OUT20/9933

**Sydney Business Park, Stage 3 (SSD 10477)
EIS**

The following recommendations are provided by DPIE Water and NRAR.

Figure 6.7: Riparian Protection Areas (Source: Growth Centres SEPP)

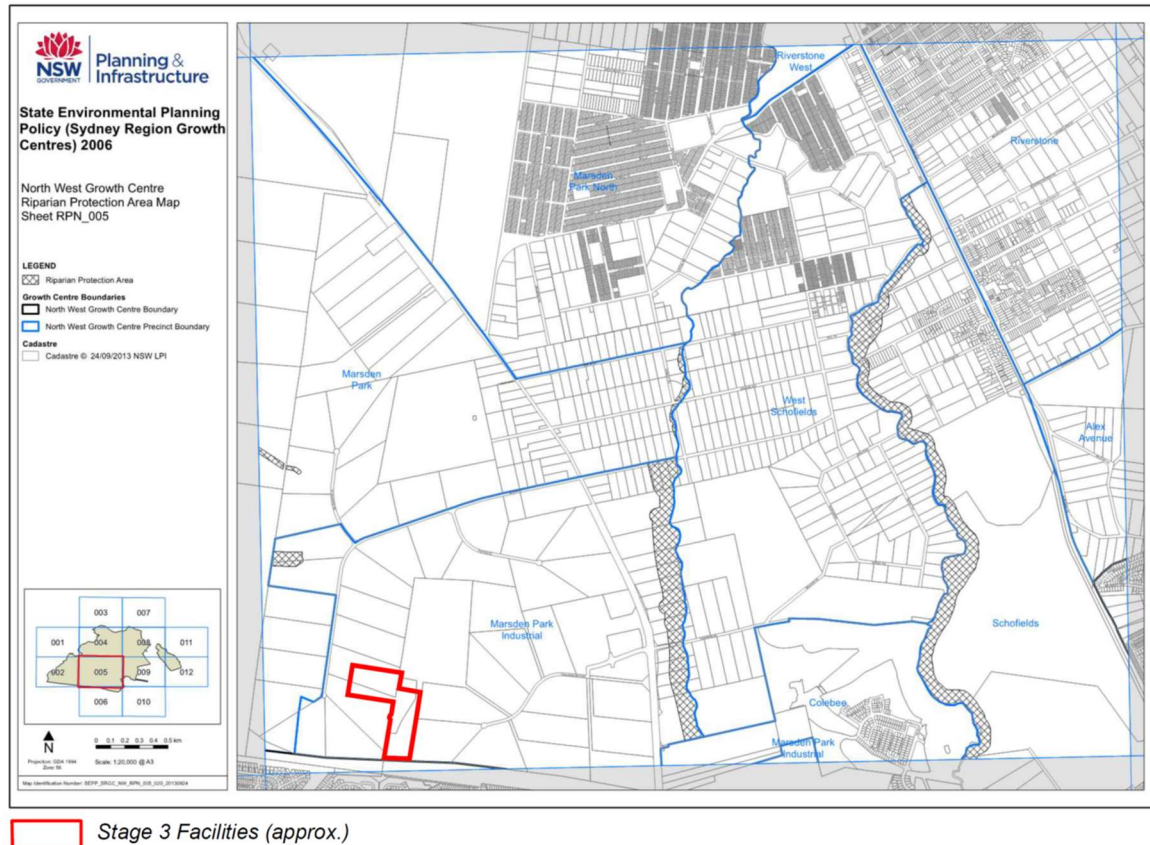
- The property contains a 1st order watercourse. The proponent should clearly show a ten metre setback from the watercourse top of bank and the development of a vegetated riparian zone (VRZ), or detail how Blacktown City Council will satisfy this requirement. Requirements for riparian corridors are detailed in the NRAR Guidelines for controlled activities on waterfront land
https://www.industry.nsw.gov.au/_data/assets/pdf_file/0004/156865/NRAR-Guidelines-for-controlled-activities-on-waterfront-land-Riparian-corridors.pdf
